Comments for Planning Application 23/02728/FUL

Application Number: 23/02728/FUL

Address: Plot 5 Earnley Gardens Almodington Lane Almodington Earnley Chichester West Sussex PO20 7JR

Proposal: Two storey side and rear extensions and single storey rear extensions to plot 5.

**2. Existing - Site Location Plan**  
scale 1: 1250

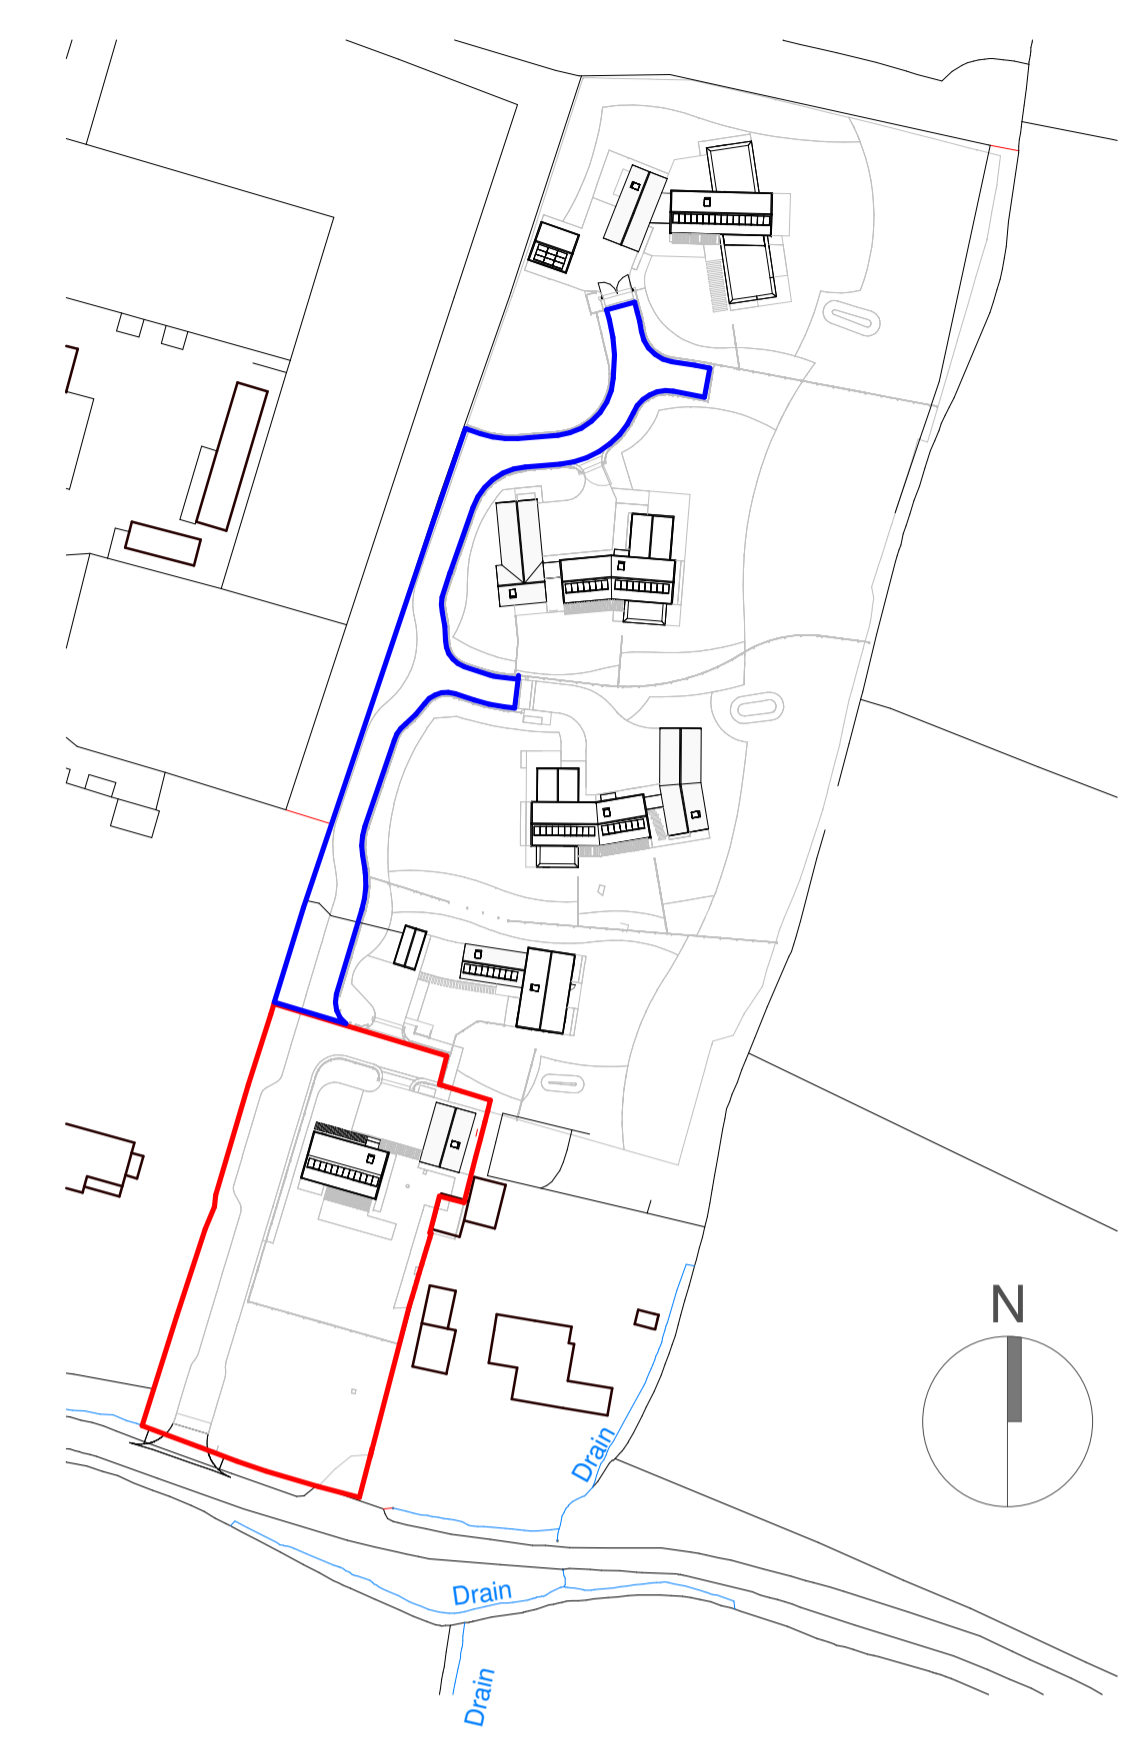
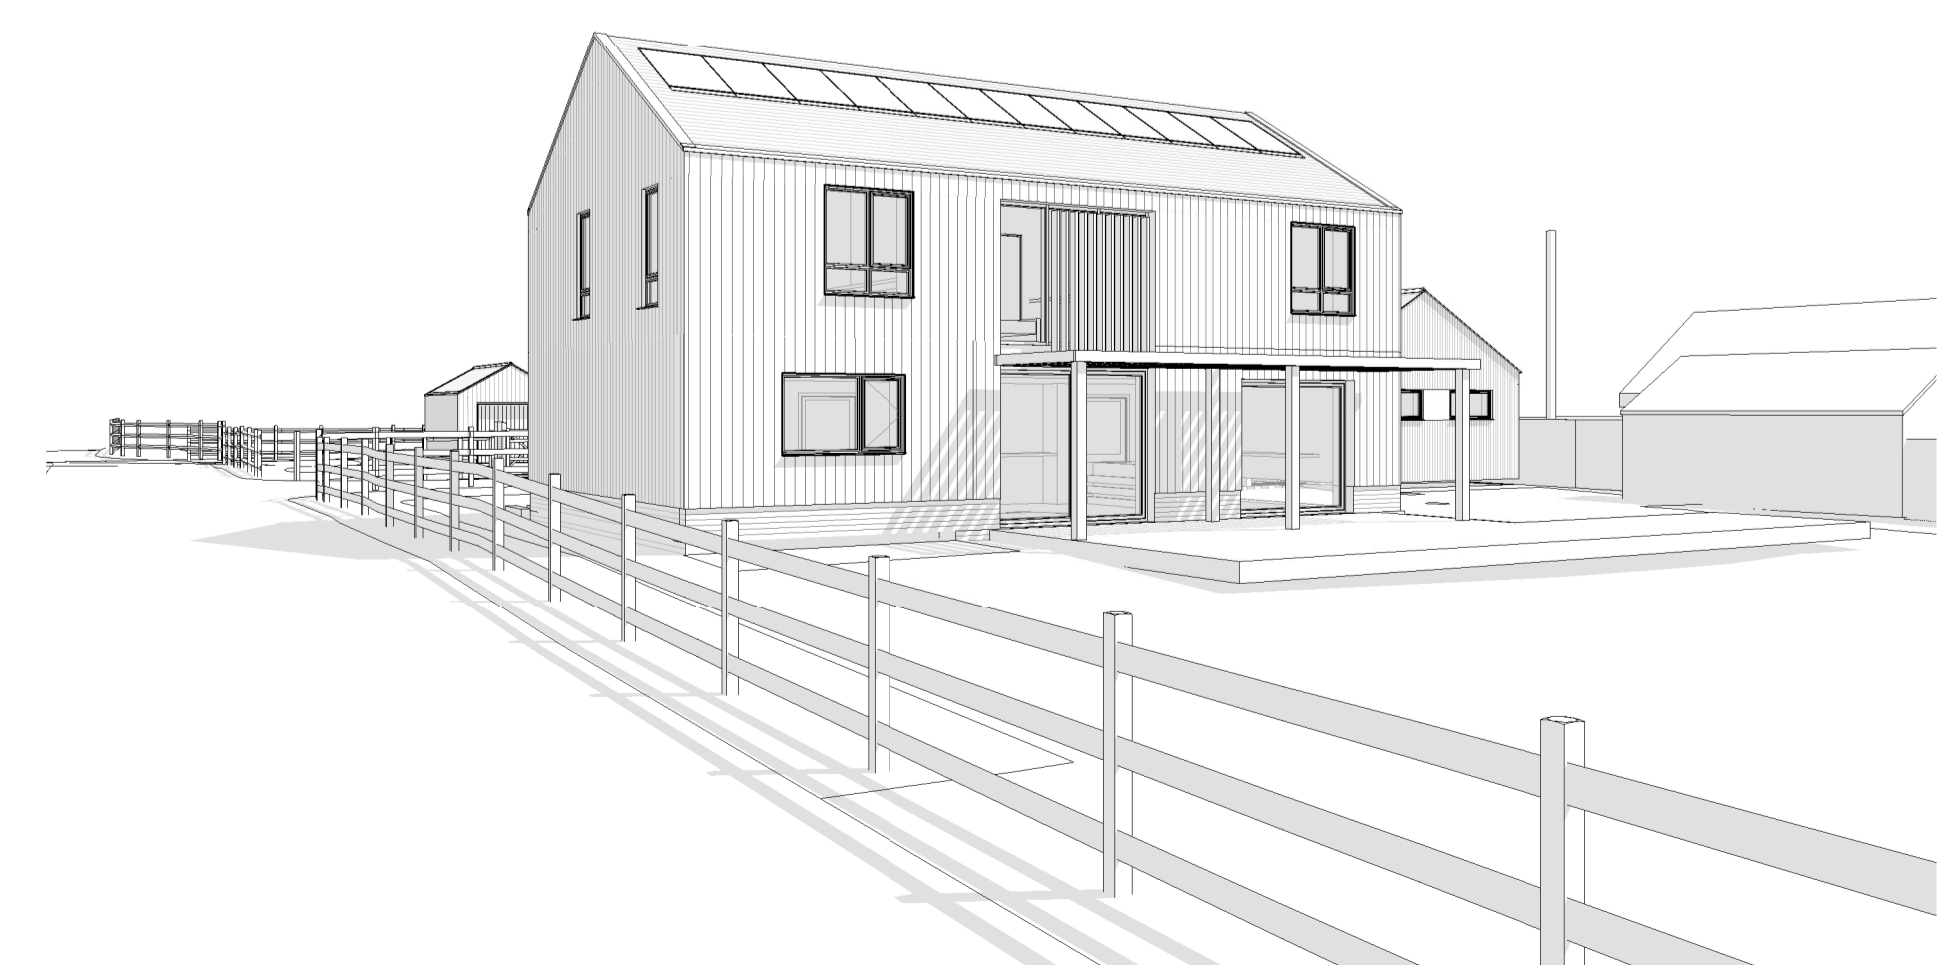
Comment: The planning application shows a map of the property 5 Earnley Meadows bordered in red ink.

This area covers and blocks the roadway giving access to houses of 1,2, 3 and 4 Earnley Meadows

The roadway from Almodington Road into Earnley Meadows and to the said houses should be marked in blue ink which allows them freedom of access in accordance with the legal documents of sale and Land Registry deeds

Please amend the drawings before approval is given
